From: Biazar, Shahab
Sent: Thursday, December 05, 2013 11:29 AM
To: 'Lawerance D. Read (lread@readengineering.com)'
Cc: Cherne, Curtis; Wolfe, Bryan K.; 'jab-engineering@hotmail.com'; 'tatefishburn@msn.com'
Subject: HME Specialists Grading and Drainage Plan (A12/D008C)
Attachments: f_056_floodproofing_nonres_5nov12.pdf

Based upon the information provided in your submittal received 11-25-13, the above referenced plan cannot be approved for Building Permit until the following comments are addressed:

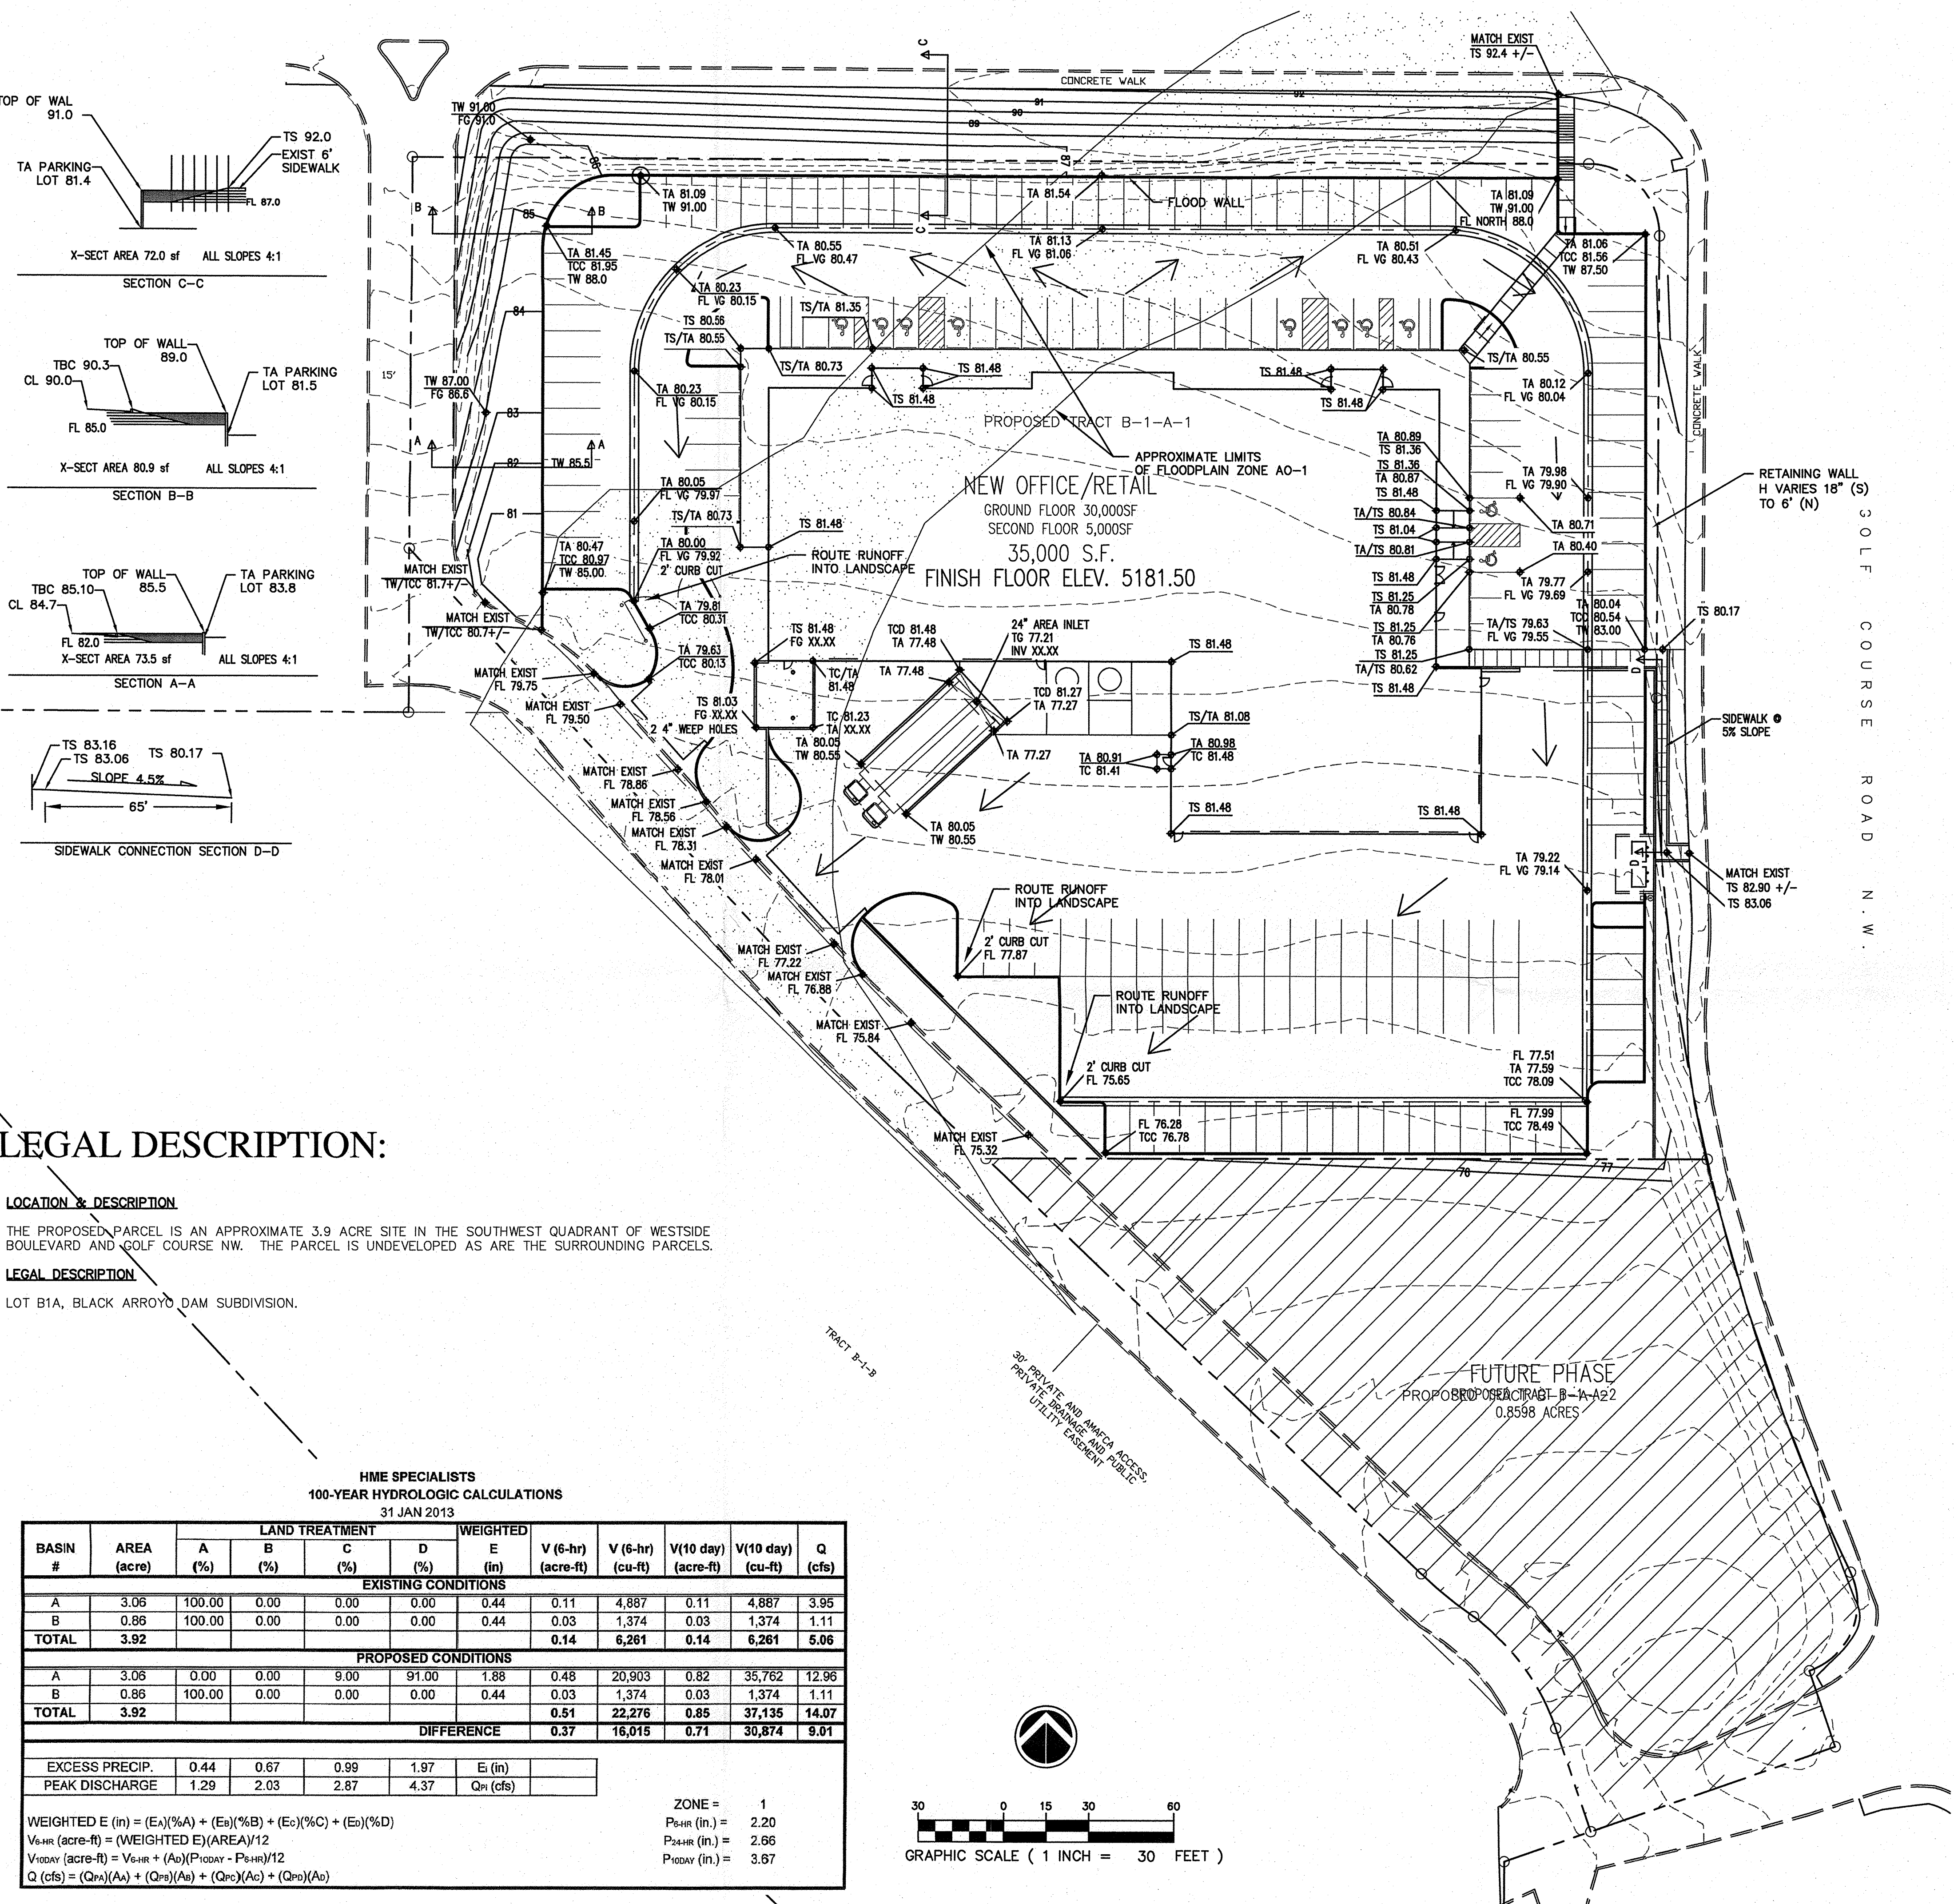
1. Please provide more detail and dimension on section C-C. Provide documentations that the slopes beyond the sidewalk within the right-of-way meet the roadside design guidelines.
2. Portion of the proposed retaining wall at the northeast corner of the project is extended into the right-of-way. This portion of the wall should be relocated to the east and outside the right-of-way.
3. Proposed sidewalks/retaining wall along Golf Course Road should be shifted west outside the right-of-way. The parking spaces can be changed to compact parking spaces if needed. A Site Plan Administrative Amendment will be required prior to Certification of Occupancy.
4. Floodproofing Certification for the retaining wall is required by the design engineer. A copy of the certification form is attached. <http://www.fema.gov/media-library/assets/documents/2748?id=1600>
